From: Grace Palmer <[REDACTED]>
Sent: 08 February 2022 13:43
To: Laura Gibbons; Simon Davis
Cc: Christopher Best; Tom Wallace
Subject: RE: Land at Northfields Cottages, Eastergate BN/1/22/DOC
Attachments: 108.5009.551.G.pdf; 108.5009 - PLOT 18-20 1in10 rev b.pdf; 108.5009 - PLOT 18-20 1in100 rev b.pdf

Subject: RE: Land at Northfields Cottages, Eastergate BN/1/22/DOC

Title
DRAINAGE CONSTRUCTION DETAILS

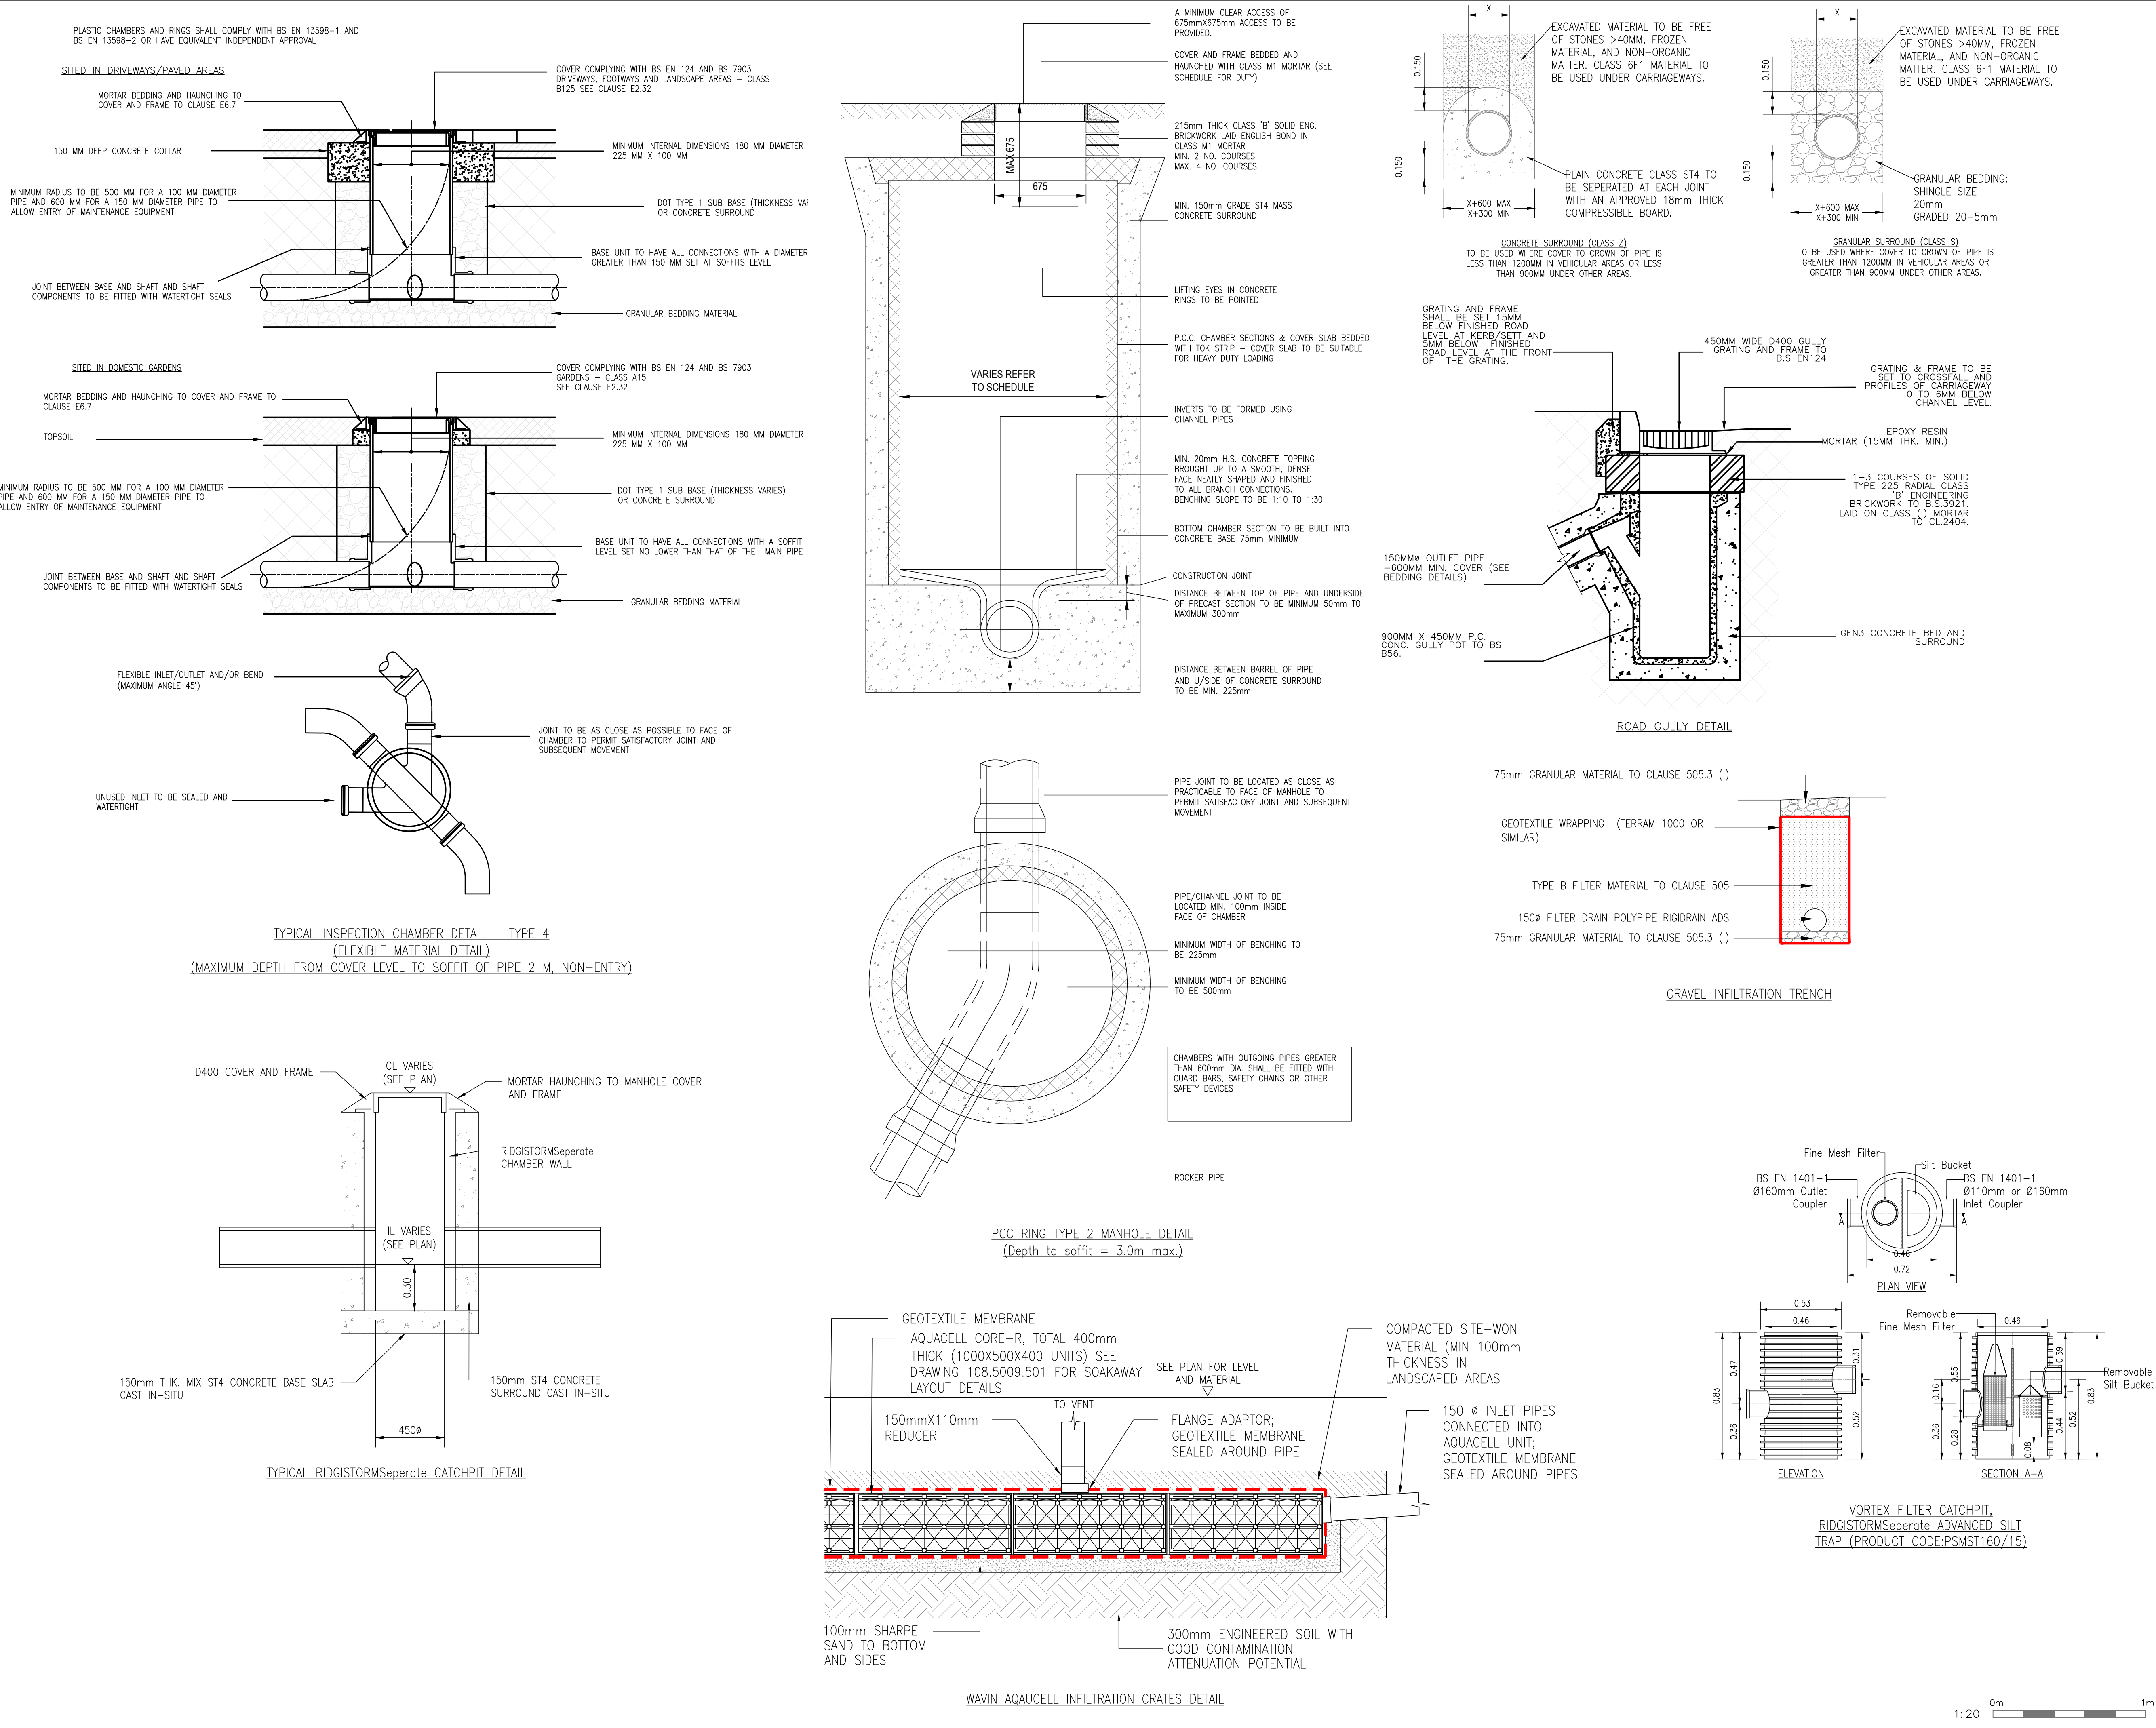
The construction detail for the crate soakaways has not been amended to reflect my previous comments. As requested previously please can this be updated to not state "total 400mm thick" and to include minimum cover depth. The crate depths vary and so the detail should be clear that thickness varies and is detailed on the layouts. Ideally a table with the dimensions of each crate soakaway should also be provided on the construction detail drawing.

Good afternoon Laura, In response to this please see attached the construction detail revised to Rev G as per your comments below.

This has removed the note stating 400mm thick and now shows depth varying as requested. Also shown added is the minimum cover level as requested. As discussed on the phone the dimensions of crates are shown on the drawings so to avoid a duplication of information this is not shown on the construction details but has been referenced on the note for ease.
